Sydney Grammar School

Access Design Assessment Report  
Schematic Design

Weigall Sports Complex  
SSDA 10421

Project: Weigall Sports Complex  
Document Type: Access Design Assessment Report  
Our Reference: P220\_051-2 (ACCESS) LB

Drawing Title
BUILDING 01
SPORTS FACILITIES BUILDING
GENERAL ARRANGEMENT PLAN
GROUND

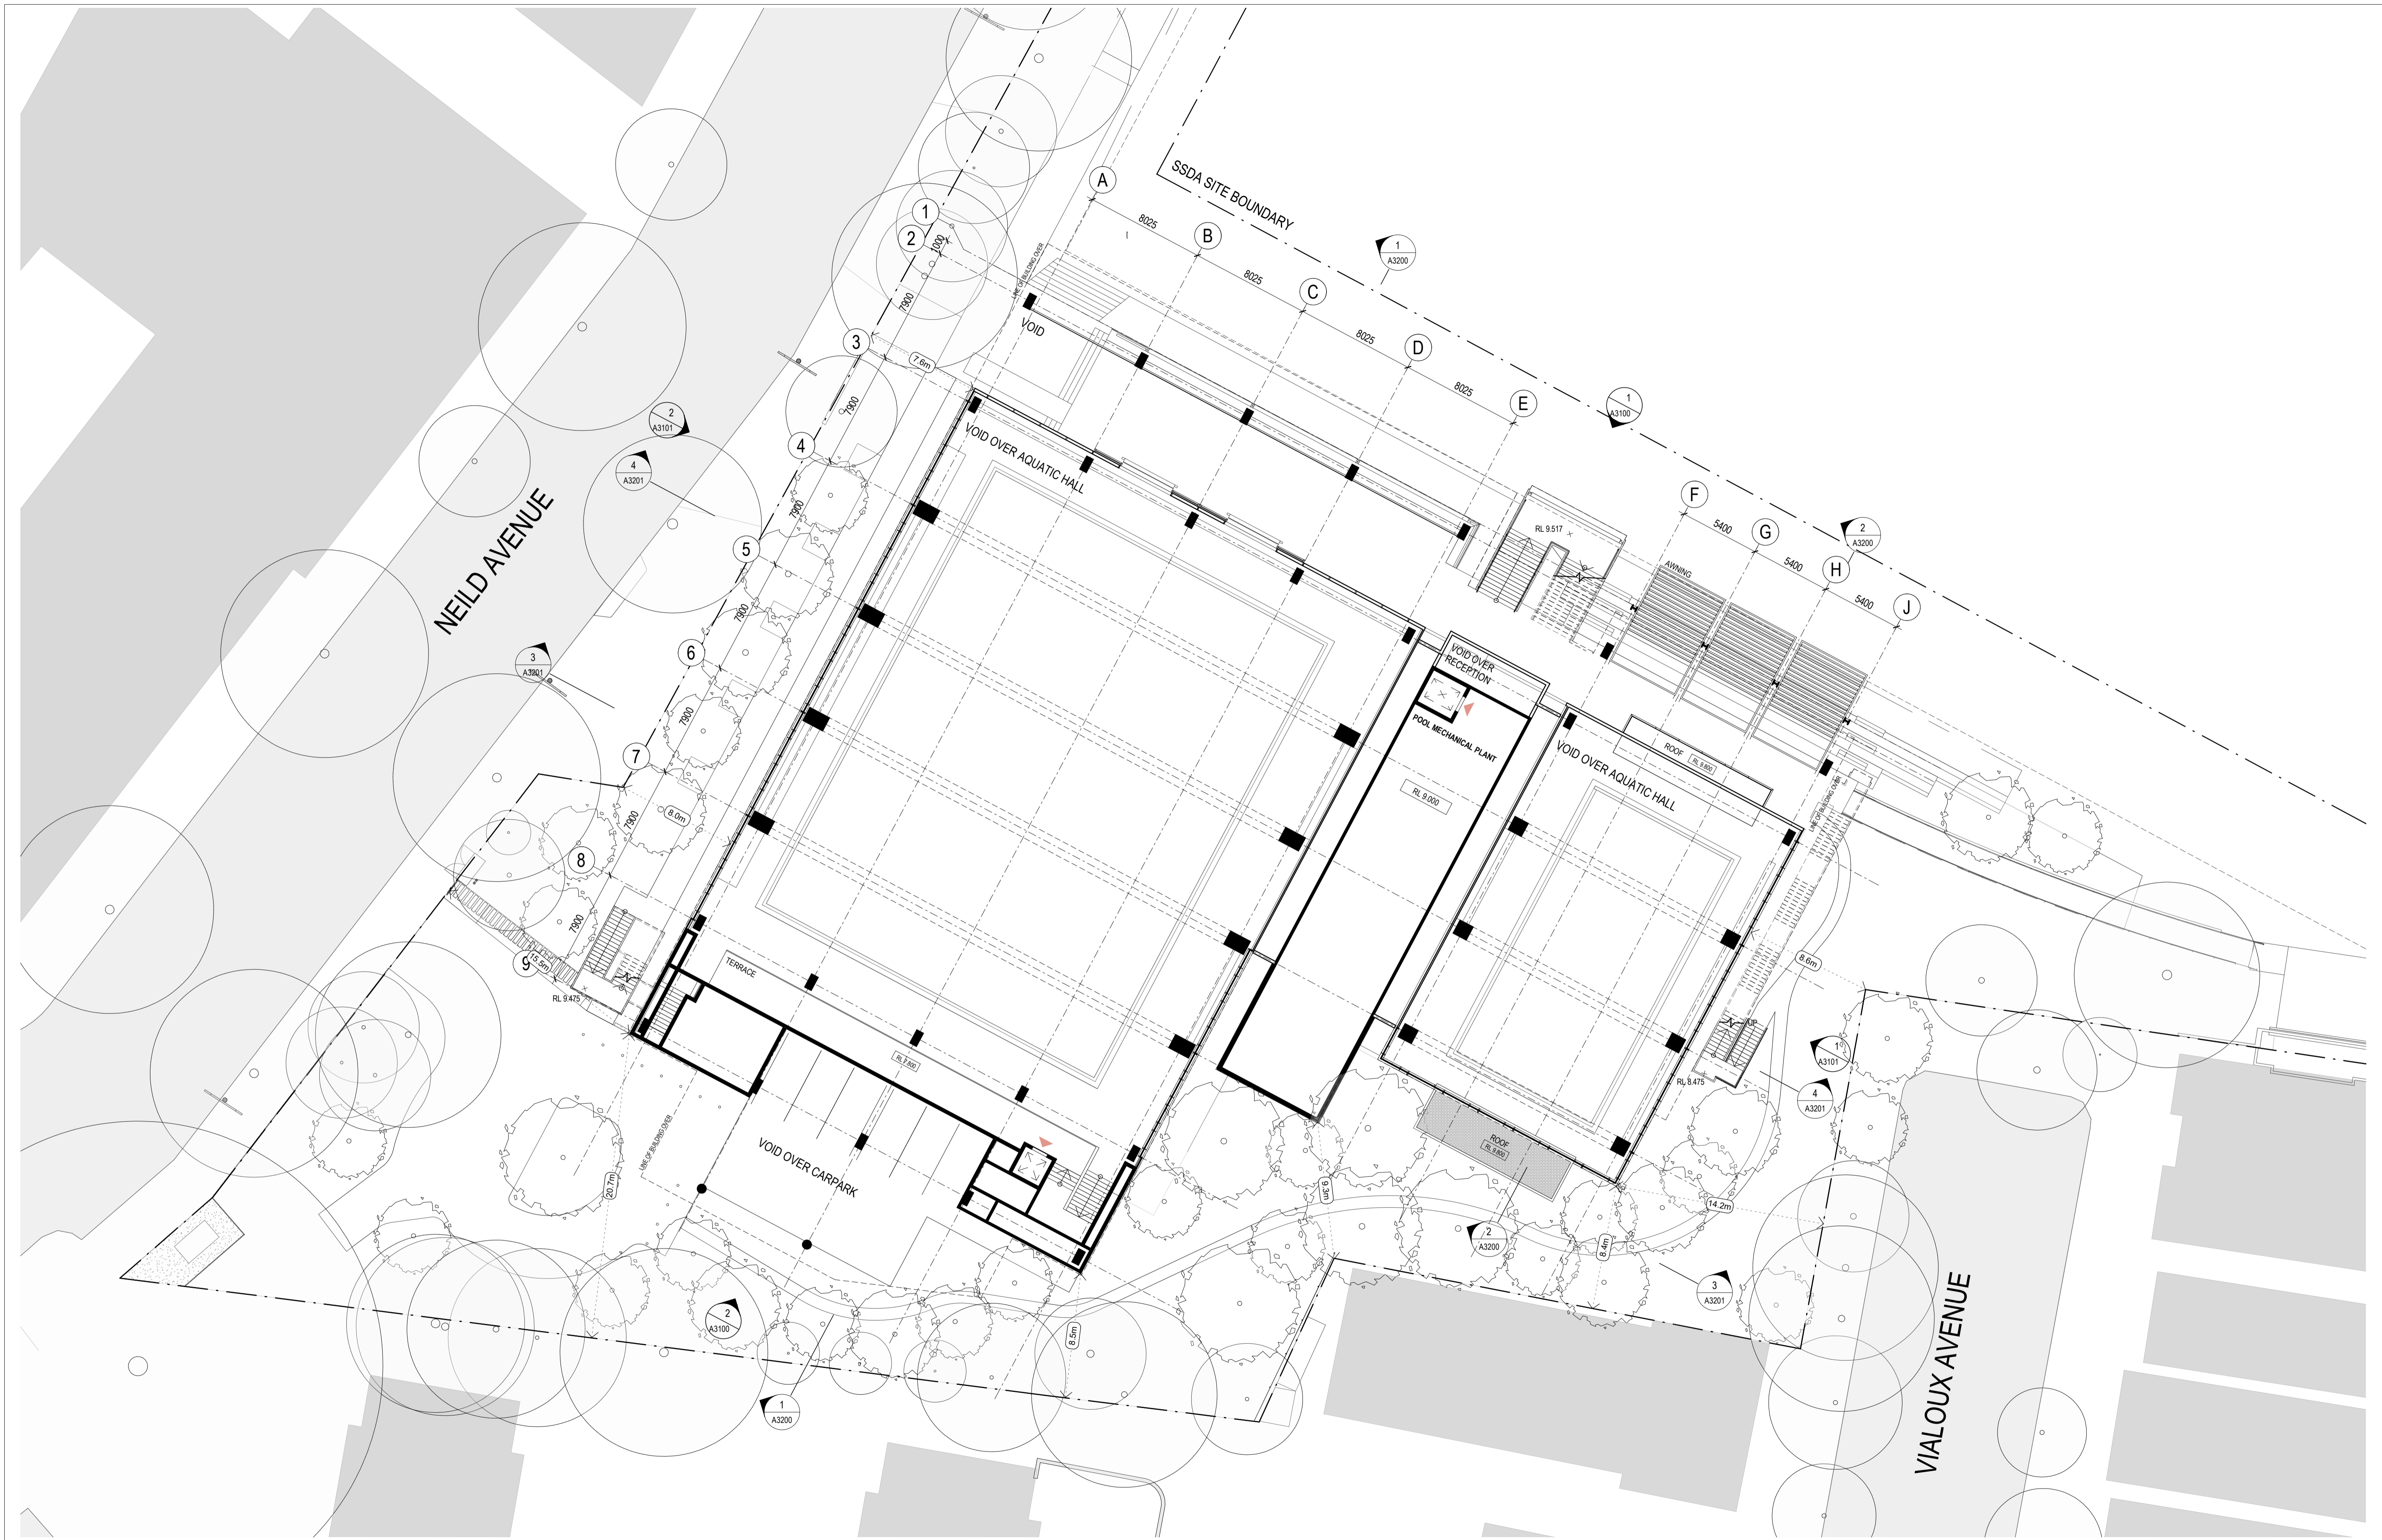
DESCRIPTION	COMMENT	RESOLUTION
Pedestrian entries	The main pedestrian point of entry will be from Nield Avenue.  A preliminary review has revealed the entries are capable of complying, however landscaping plans would be required to confirm	Landscaping plans to be provided for assessment.

DESCRIPTION	COMPLIANCE DEPARTURE	RESOLUTION
Accessible parking and the shared area	<p>2 accessible parking spaces are shown. 1 adjoining carpark and one in the Southern carpark. Spatially parking spaces are capable of complying.</p> <p>Car parking spaces have been calculated at a rate of 1 space for every 100 carparking spaces (school) under D3.5.</p>	<p>Accessible car parking spaces shall be designed in accordance with AS2890.6 (2009), including (but not limited to) the following:</p> <ul style="list-style-type: none"> <li>▪ Minimum dimensions of 2400mm (W) x 5400mm (D);</li> <li>▪ Minimum dimensions of 2400mm (W)x 5400mm (D) to the shared area;</li> <li>▪ Provision of bollard to the shared space;</li> <li>▪ Appropriate line-marking and signage; and</li> <li>▪ A head height clearance minimum of 2500mm is required to accessible car spaces and shared areas. This may be reduced to 2200mm within 1000mm of the front of the space, and to 1800mm within 500 mm of the front of the space.</li> </ul> <p>Further information is required.</p>
